Application no: H16-0729-11

Description: Proposed single storey side and rear extension

Location: 25 Spring Gardens
Spalding
Lincs
PE11 2XN

Amendment: Reduce roof pitch from 18 degrees to 15 degrees
(dwg no. 1134-02-A)

PROPOSED
FLOOR PLAN - SECTION - ELEVATIONS

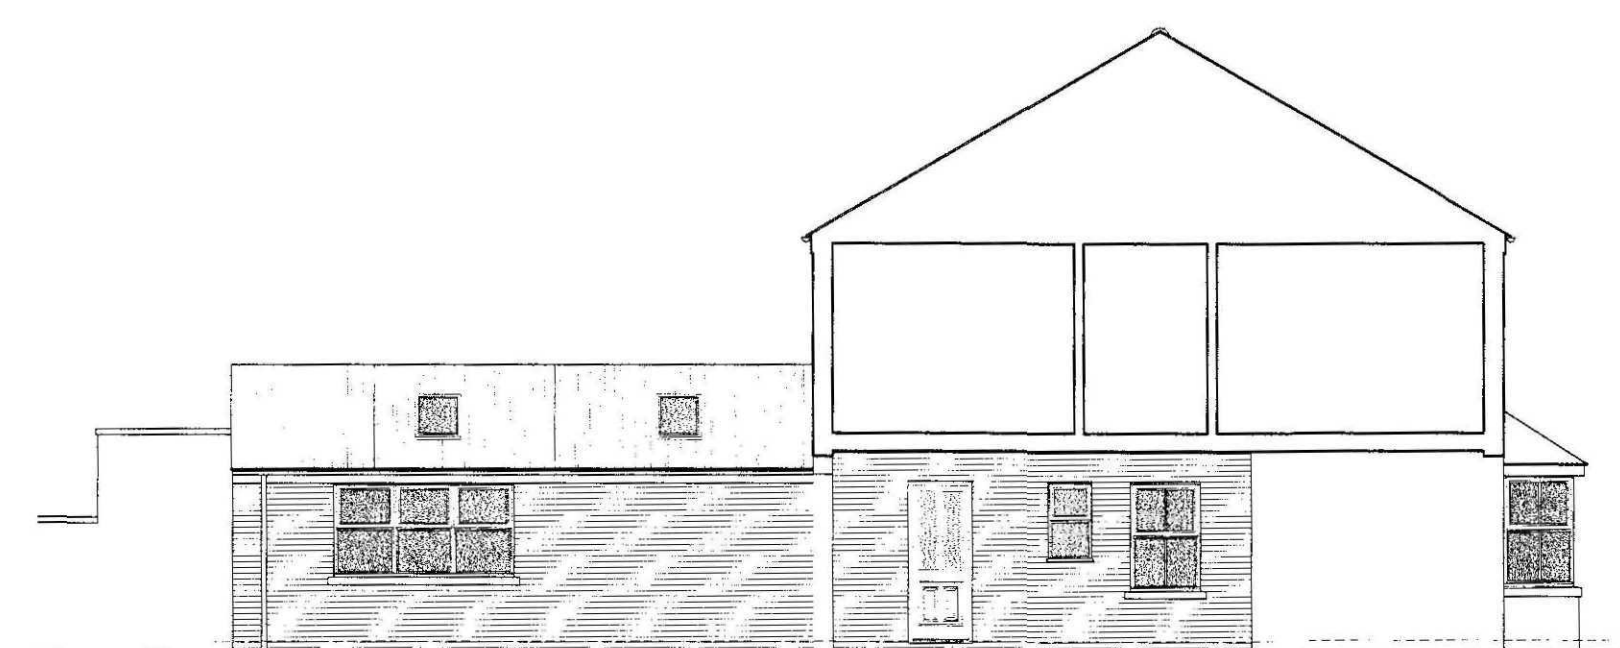
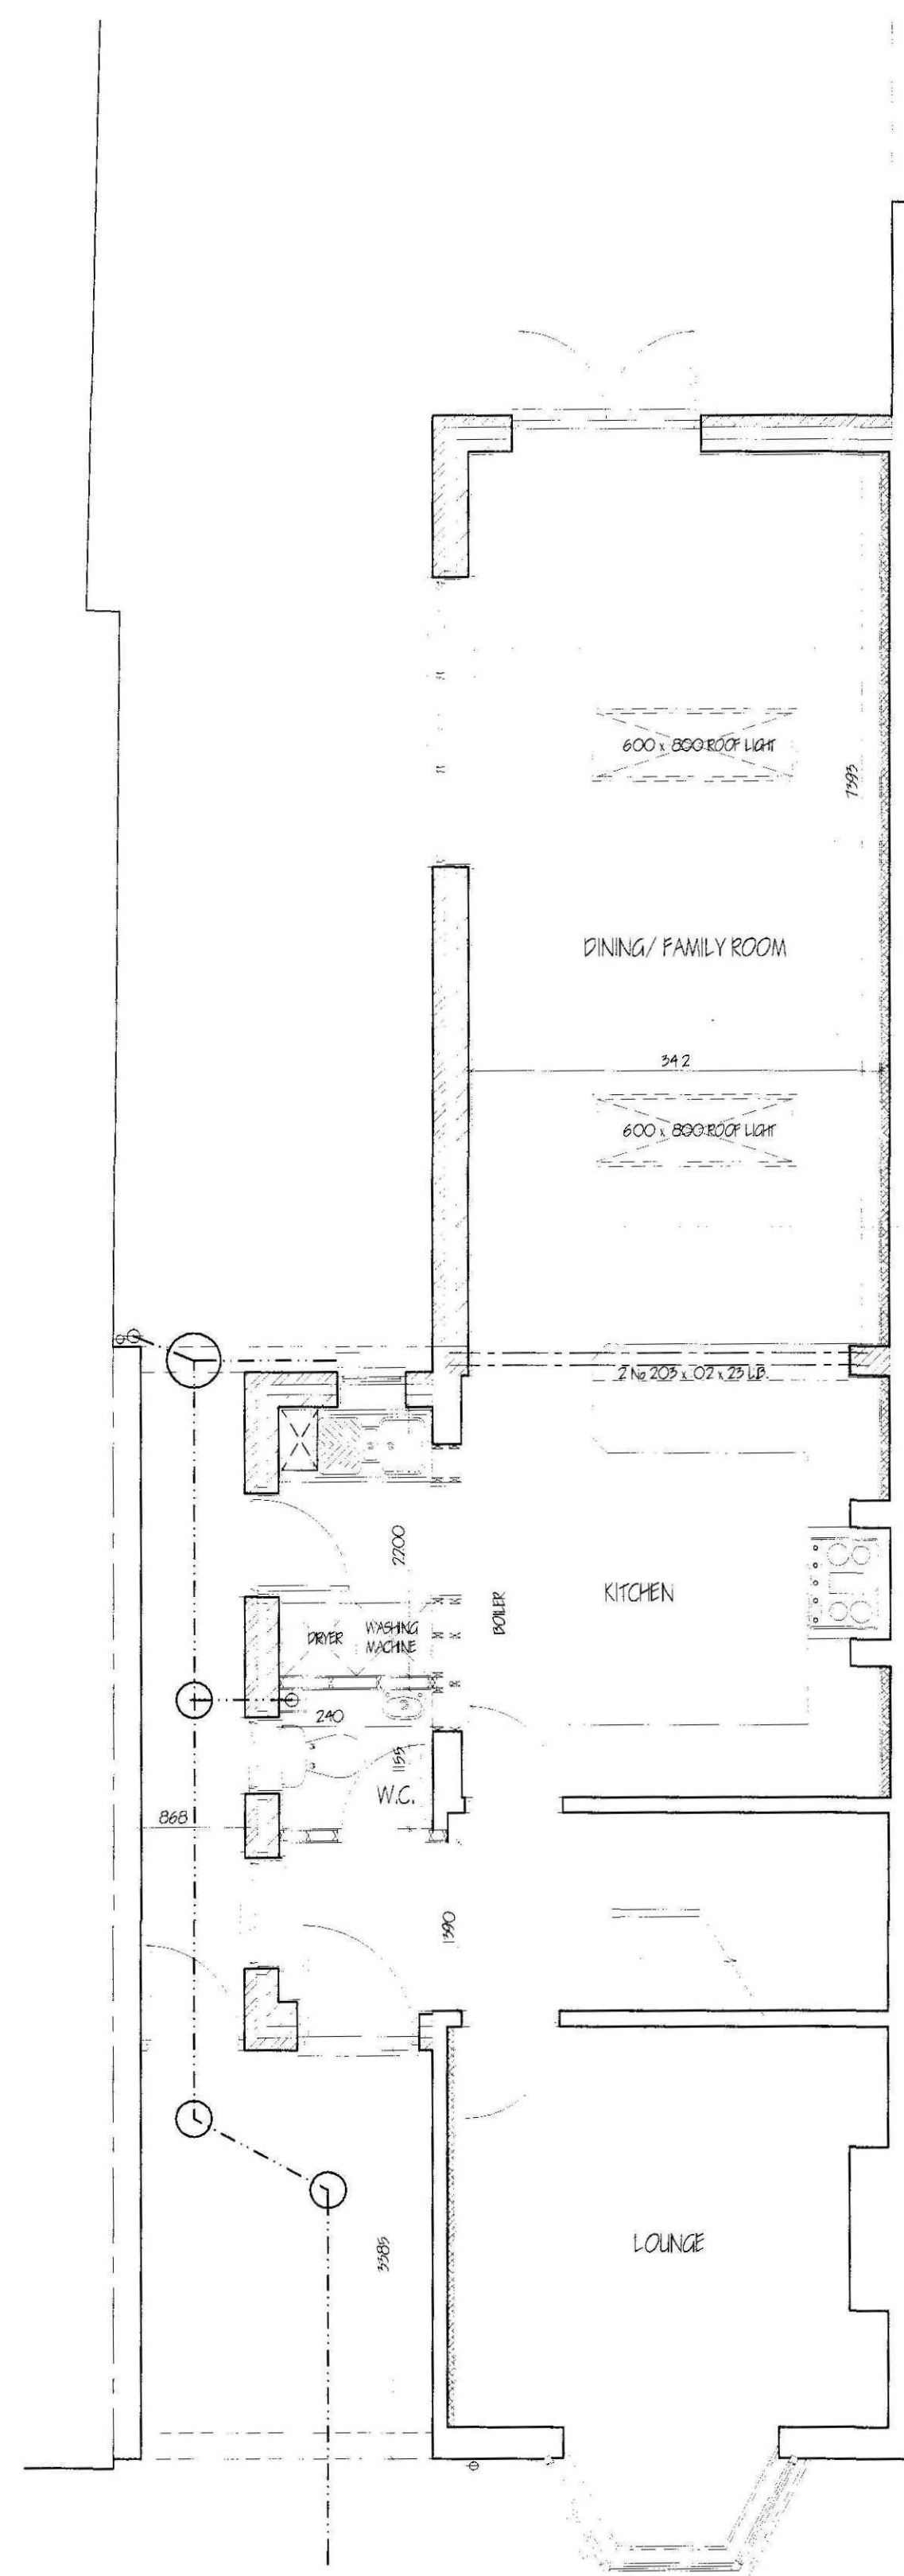
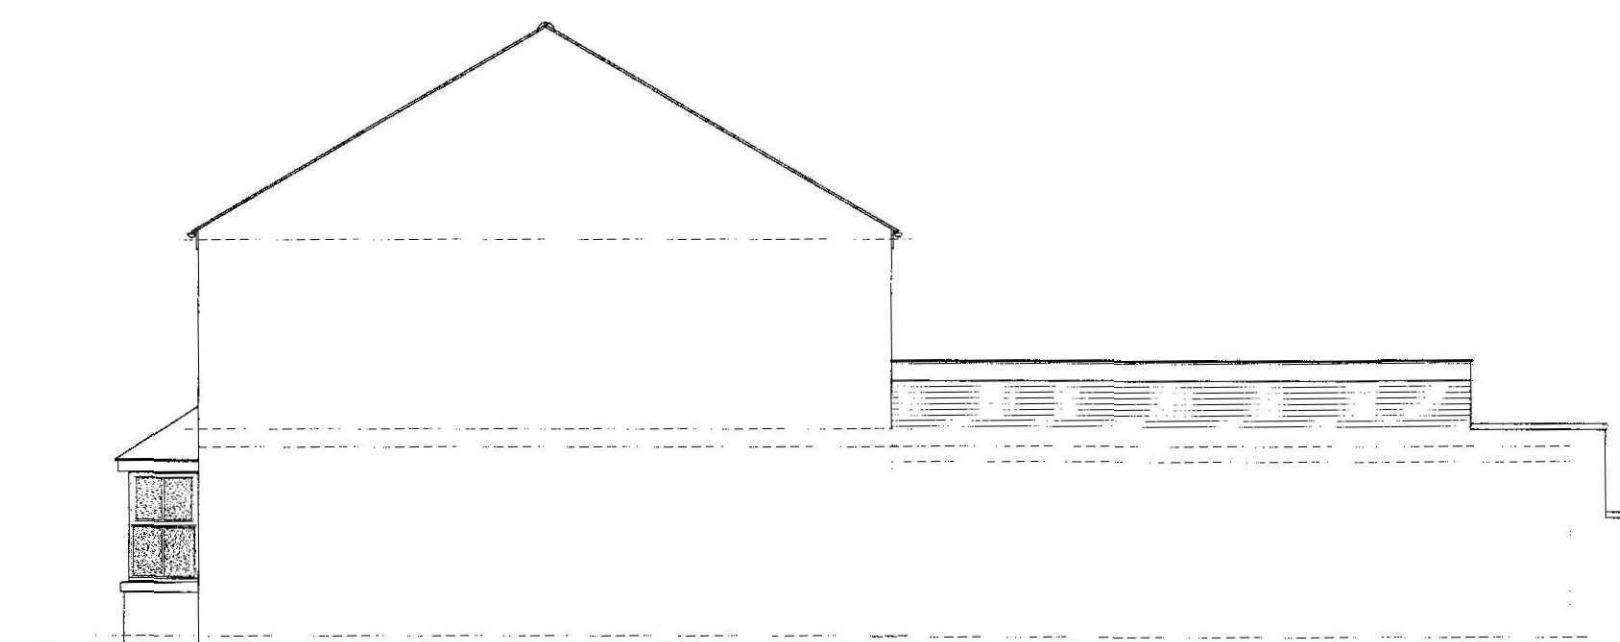
Further to our telephone conversation of today please find enclosed 2 copies of the plans amended to show the roof pitch reduced from 18 degrees down to 15 degrees thus reducing the additional height by 225mm, together with the note regarding the application of masonry paint to the North-East wall of the extension.

We feel that this will give the neighbours at 25A better light quality to the single storey rear section, due to the proposed reflective nature of the adjacent wall.
